Reference Number: 6/2022/2300/COND

DESCRIPTION: Submission of details pursuant to condition numbers - 1 (Construction Management Plan), 5 (Surface Water Strategy), 6 (Surface Water Scheme), 7 (Drainage), 8 (Foundation), 9 (Design Plan), 10 (Accessible Housing Scheme), 11 (Highway Improvement), 12 (Samples), 13 (Hard Landscaping), 14 (Soft Landscaping), 15 (Hard landscaping - roof garden), 16 (external lighting), 17 (Cycle Store), 18 (Cycle Store under-croft/Open air), 19 (Balcony Screens), 20 (Energy & Sustainability Statement), 21 (PV Cells Plan), 22 (Bat & Bird Boxes), 23 (Noise Compliance), 24 (Noise Compliance), 26 - (SuDS), 27 (Access), 28 (EV Charging Points), 29 (Parking), 30 (Bin Stores), 31 (Roof Gardens), on planning permission 6/2020/3222/MAJ

LOCATION: Beadles Volkswagen Van Centre, Harpsfield Broadway, Hatfield, AL10 9TF

Figure 2: Site Overlay of Borehole Locations

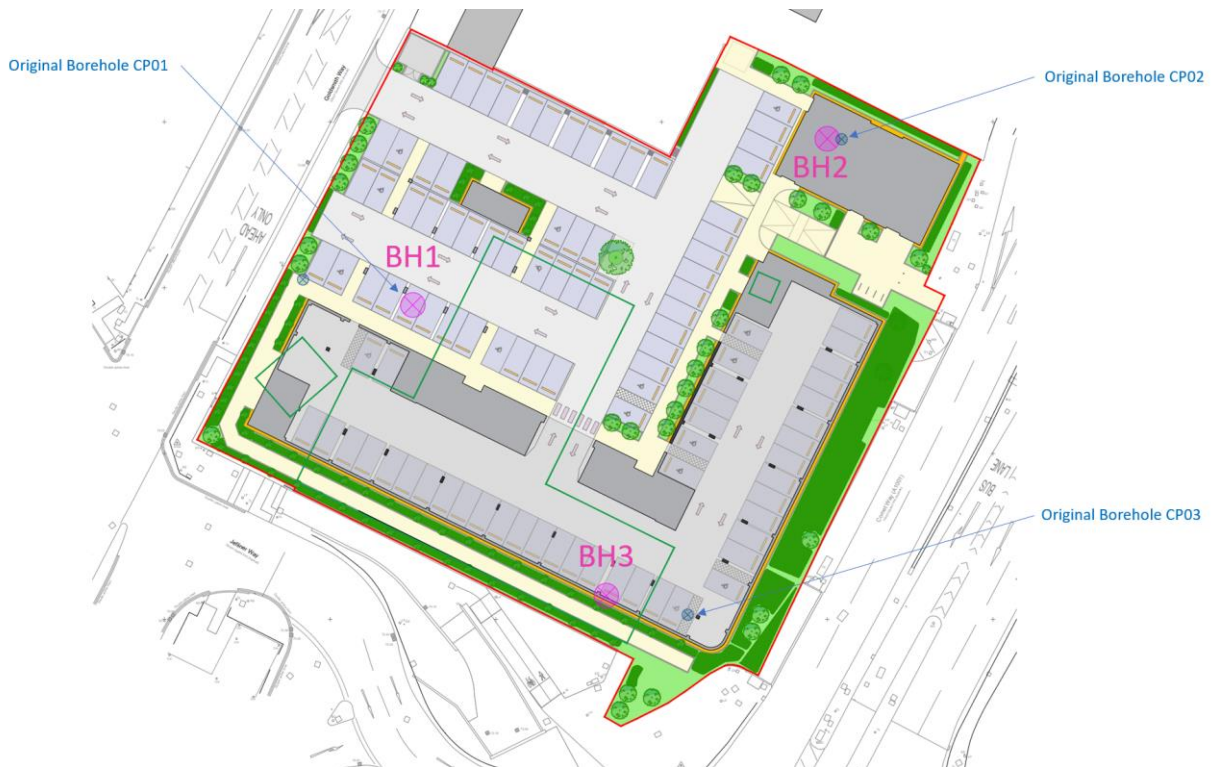
Our concern as mentioned in our initial response (dated 1st November 2022) is that the proposed piling depth finishes at the top of the Lower Sand and Gravel aquifer which is hydraulically connected with the Chalk aquifer below (principal aquifer). These geological units have recorded elevated levels of Bromate linked to historic contamination which is currently controlled by scavenging activity undertaken by Affinity Water. The piling depth proposed will penetrate the Boulder Clay layer that separates the Upper Gravel aquifer (secondary aquifer) from the Lower Gravels and Chalk, potentially creating a pathway that would hydraulically link the two aquifers allowing the Bromate to bypass active scavenging activities and affect local third-party groundwater abstractions (from the secondary aquifer) and groundwater-dependent ecosystems.

In order to consider removal of our objection of condition 8, we would require that piling does not exceed a depth below 62mAOD (a minimum of 2m above the base of the Boulder Clay, based on the limited information available from the two onsite boreholes). We expect

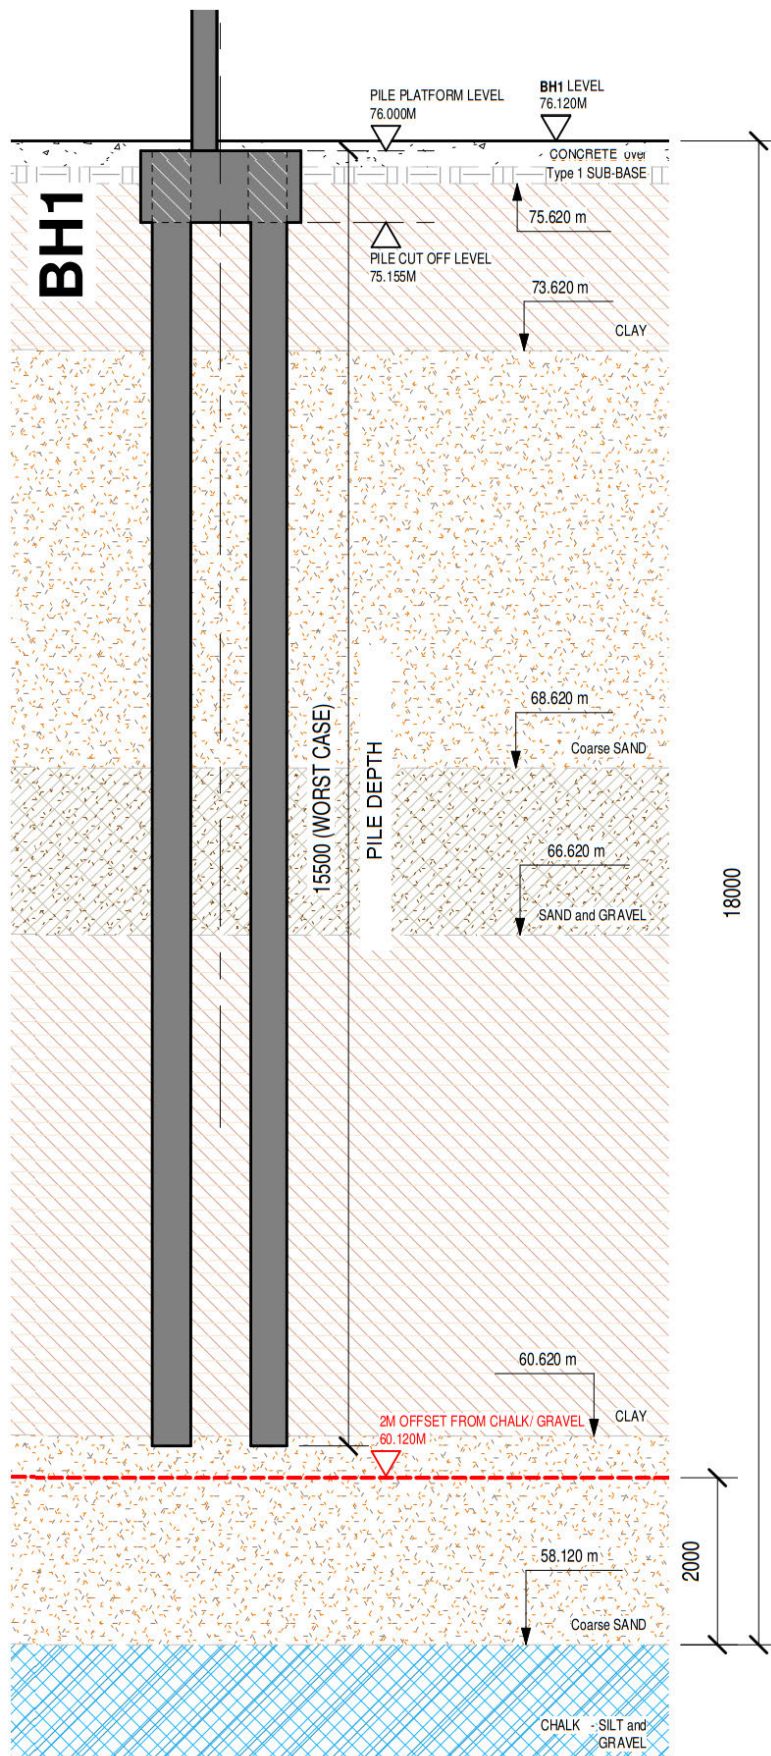
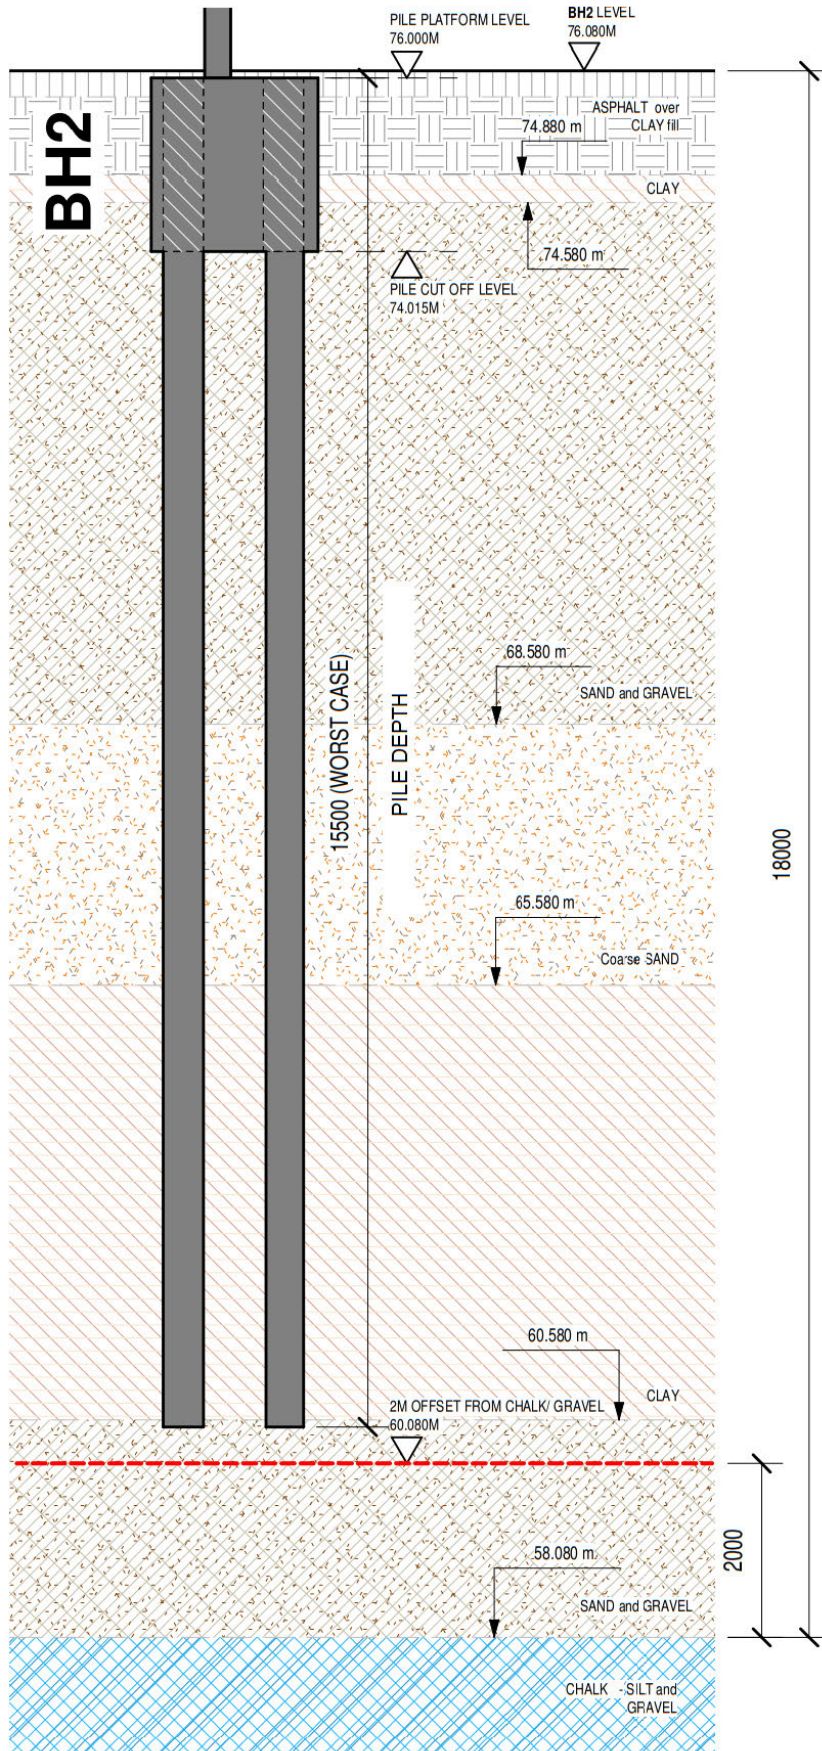
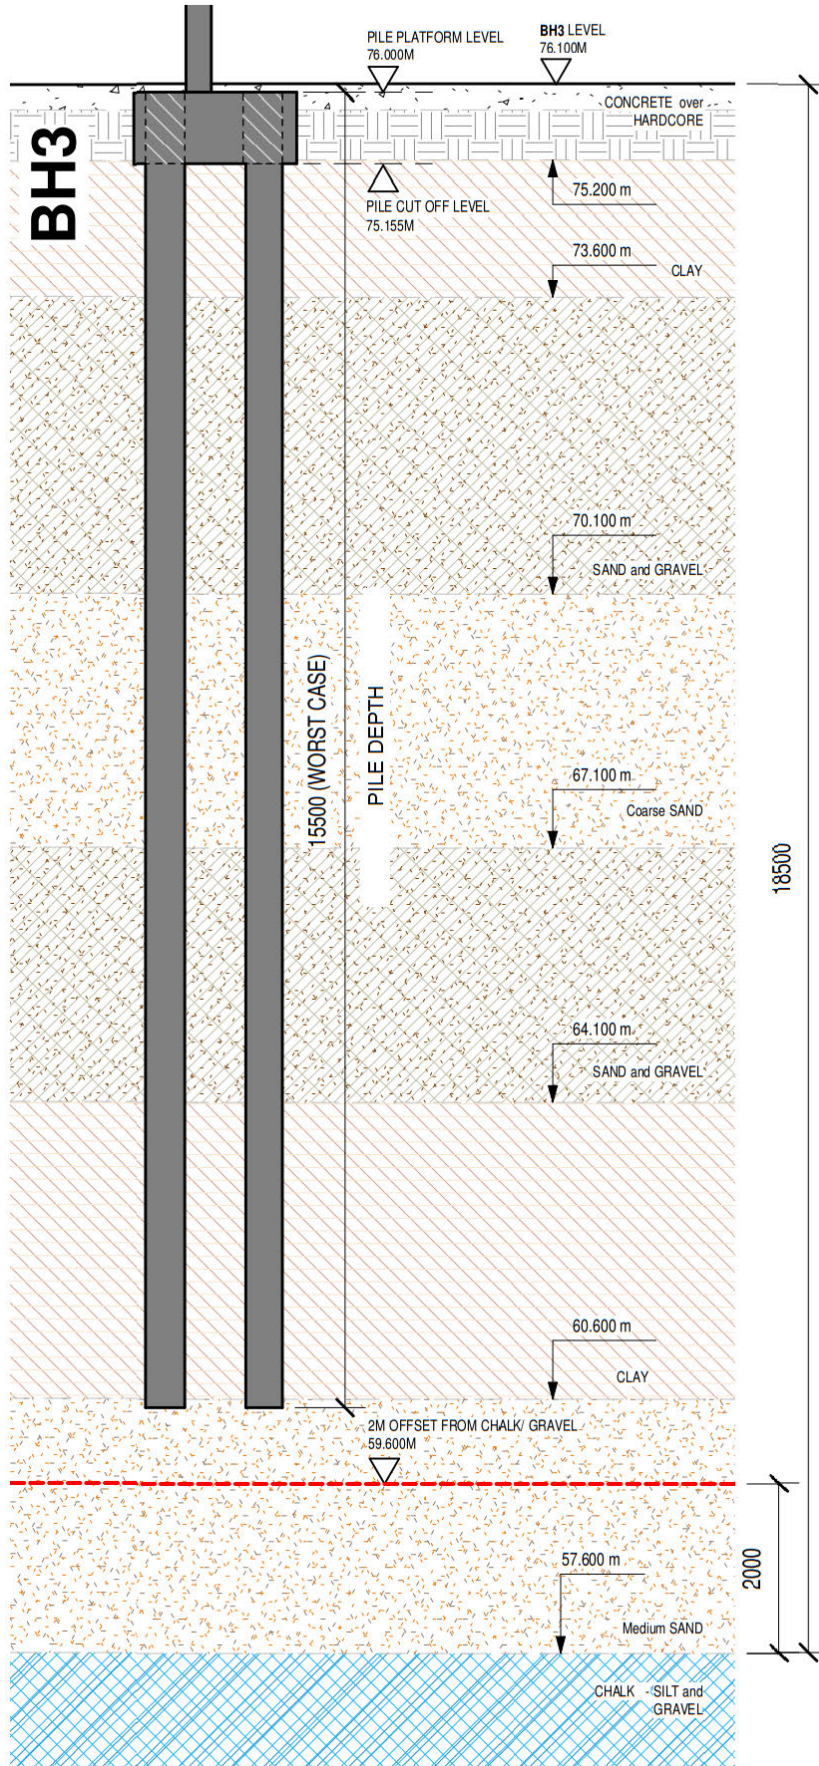
Affinity Water continues to hold its **objection** to condition 8 and this is due to the piling depth mentioned in the supporting document.

that once the piling method statement has been updated, we would get the opportunity to review prior to discharging condition 8.
